Consultation Response from KC, Conservation & Design
2024/90506 6, Yew Tree, Yew Tree Lane, Slaithwaite, Huddersfield, HD7 5UD
Listed Building Consent for demolition of existing lean-to, erection of single storey rear extension, installation of 2no. new windows and alterations
Date Responded: 16.4.2024
Responding Officer: Sue Brooks
Responding Ref: CV 13/514

Proposed rear/north west facing elevation (1:100)

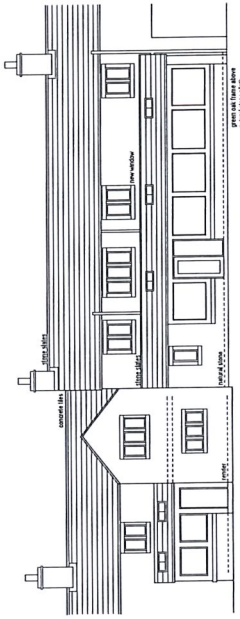
The application proposes to replace it with a substantial single storey rear extension which extends almost the full width of the building, with the demolition of a large section of the rear ground floor wall of the listed building to create open plan living space on one side. The proposed materials of the extension are stone walling, extensive glazing with green oak timber framed windows, a stone slate roof, oak door and three conservation roof lights.

Although similar in design to the extension at 5 Yew Tree, the proposed extension at 6 Yew Tree is significantly larger, and as the north wall of the host building is in stone, will be far more harmful. Although the use of natural stone is used at low level and for the proposed WC, with a stone slate roof, a long range of green oak framed windows does not respect the character of this visible elevation, which is characterised by few openings and extensive coursed stone walling.

A pair of mullioned windows is proposed on the first floor to provide light into the staircase. This is acceptable subject to details being submitted for approval, with white painted timber windows, slim double-glazed units and ashlar window surrounds.

If the application is supported, we would recommend that new rainwater goods are in timber or cast iron with traditional profiles, and not uPVC as specified.

Proposed ground floor layout (1:100)

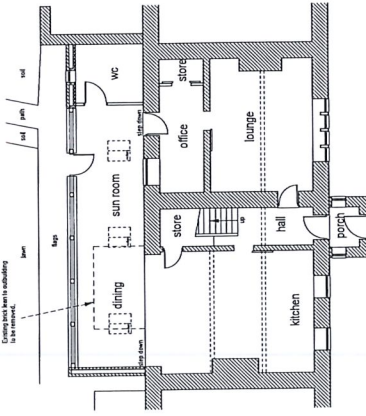
We have no objections to the demolition of the existing extension, which harms the character of the listed building, and we may be able to support an application for a smaller replacement single-storey extension with a narrower opening from the main cottage. In its current form we are unable to support the proposal.
